Our ref: GA/D10753

29 February 2024

## **PROPOSED SCREEN AT ST. PHILIP & ST. JAMES CHURCH, WOODSTOCK ROAD, OXFORD**

DWG 188/10

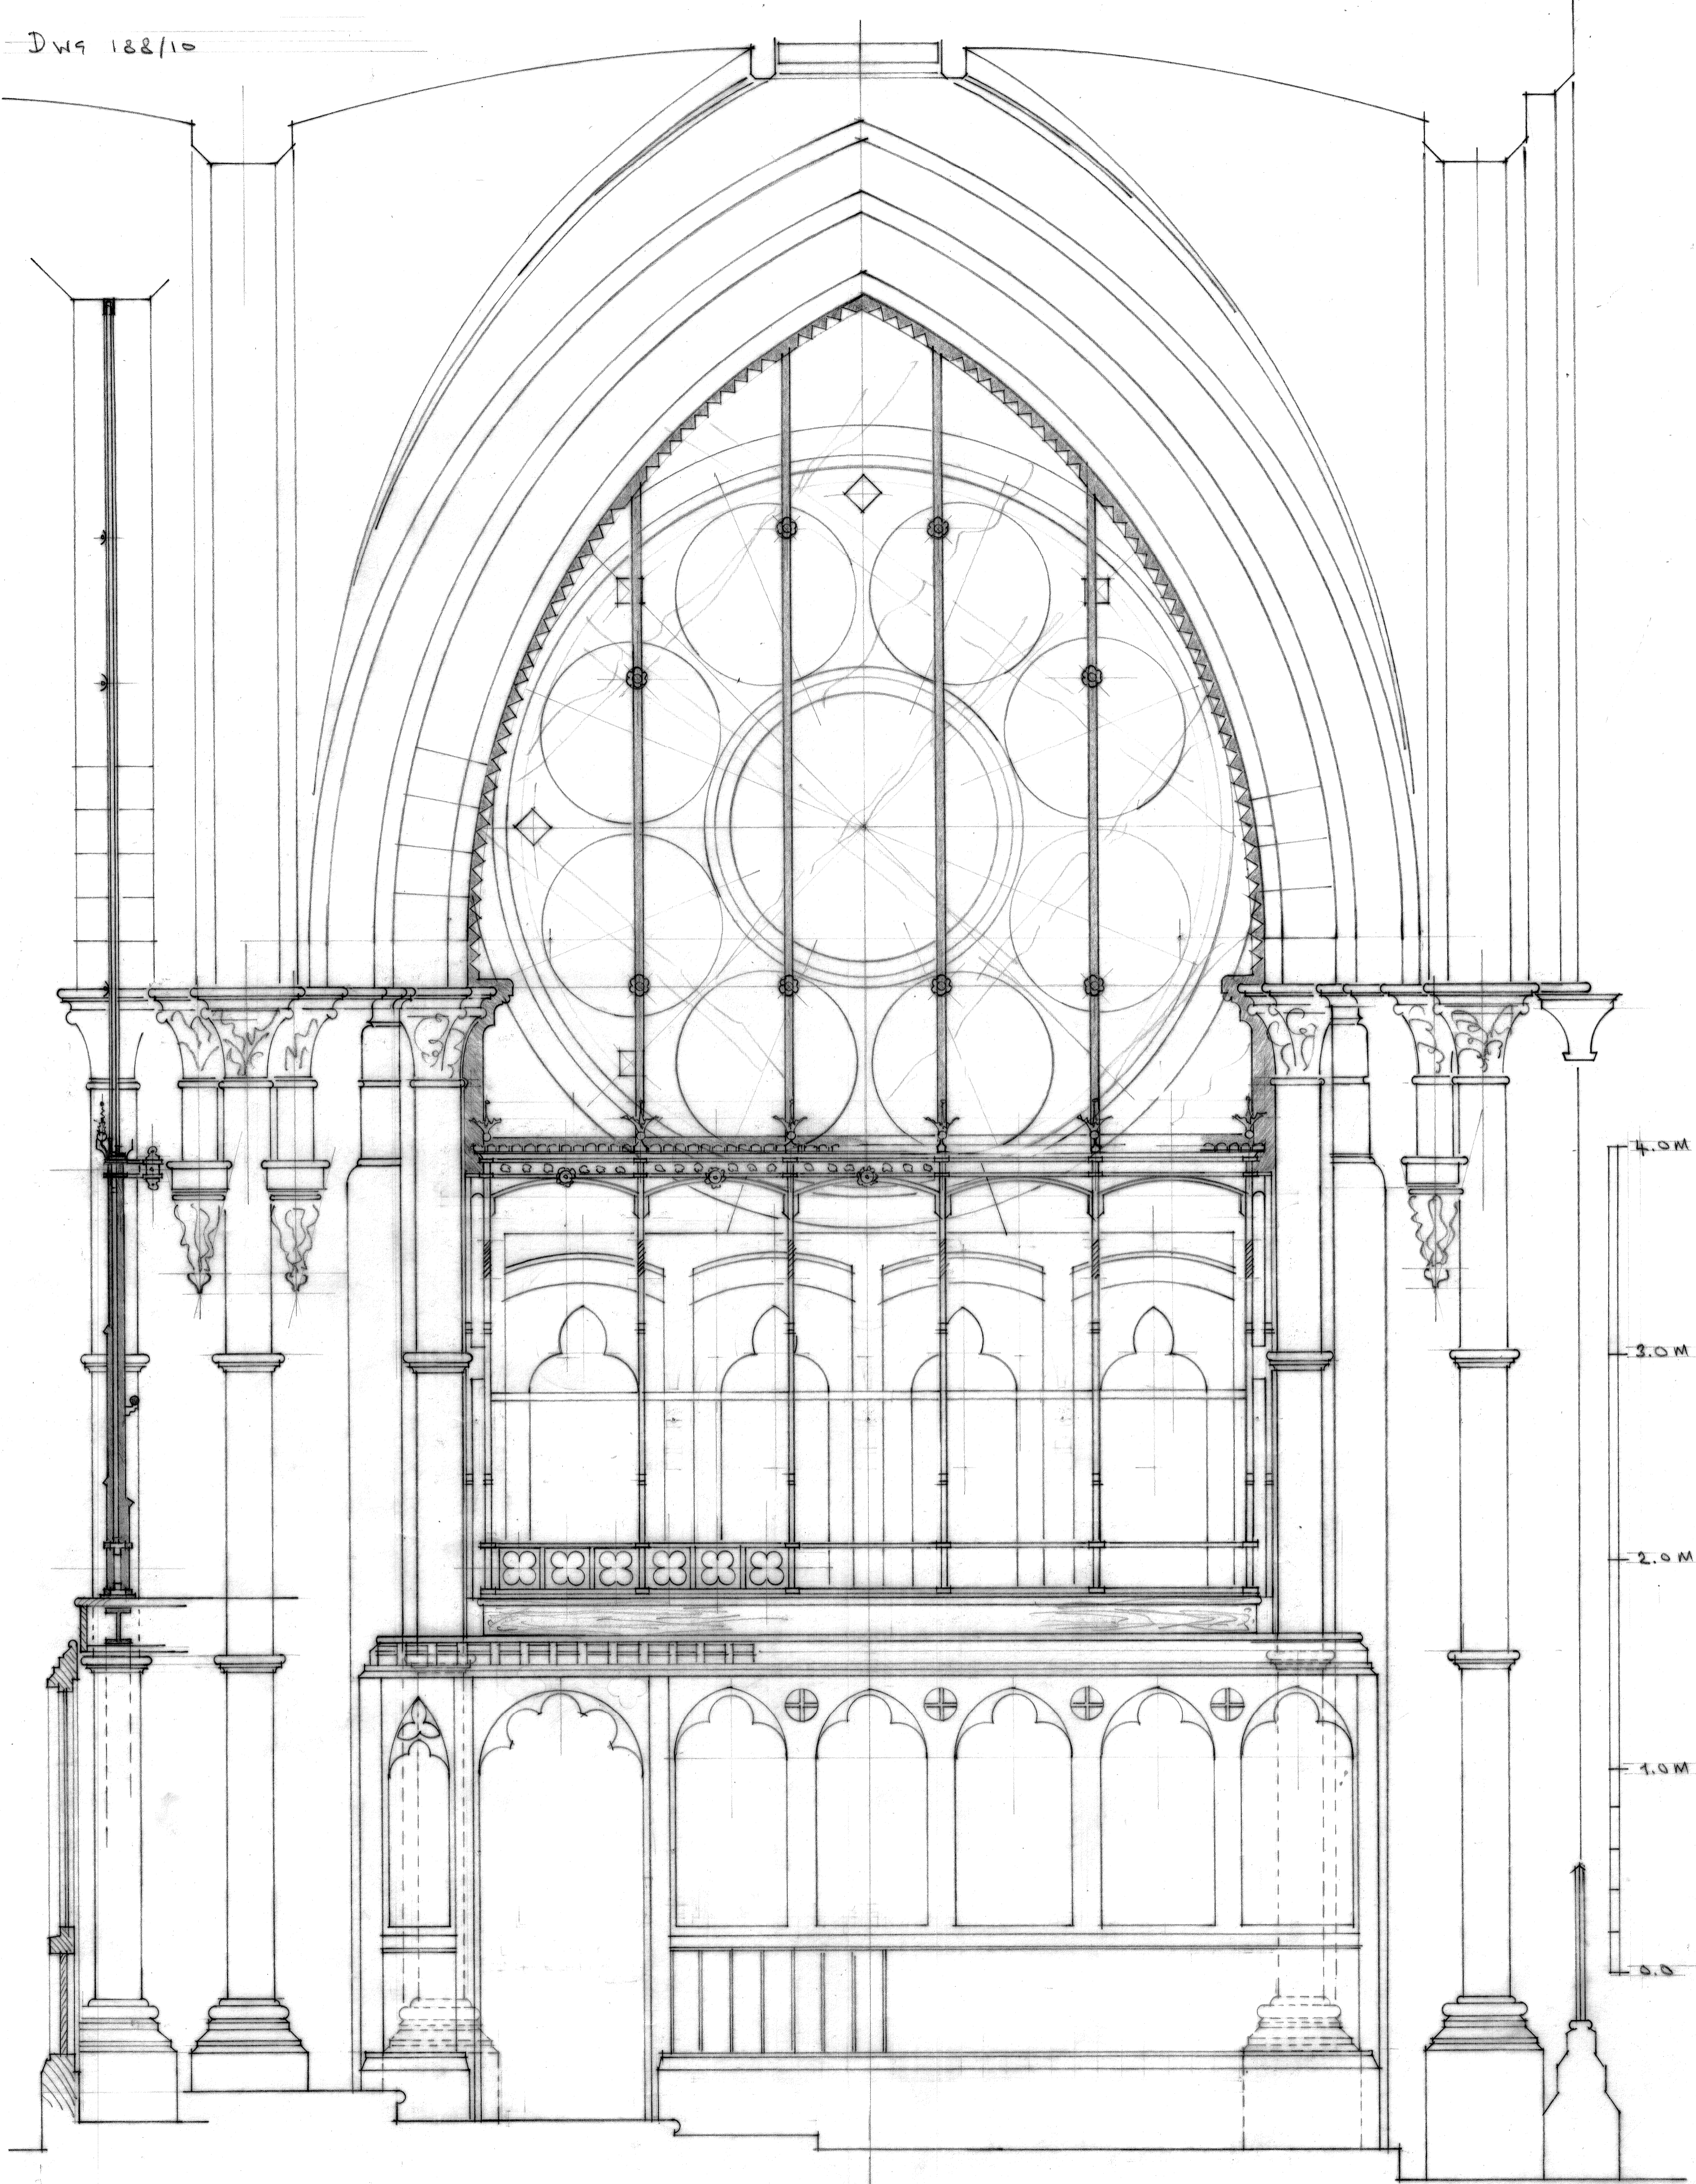
The 21.5mm thick glass weighs approximately  $54\text{kg/m}^2$  which, from our estimation of the area of the glazing of  $12.6\text{m}^2$ , gives a total weight of 678kg or 6.65kN.

The horizontal force required to be applied to the handrail is 0.74kN/m.

The existing posts have a slenderness ratio in excess of 180 and will have a tendency to bend in the weaker axis, ie, the 36mm width, under vertical loading. This tendency to bend will apply a force to the edge of the glass, possibly causing it to crack.

Introducing a horizontal member to the posts at about mid-height will restrain them on the minor axis and, hence, reduce the slenderness ratio to an acceptable level.
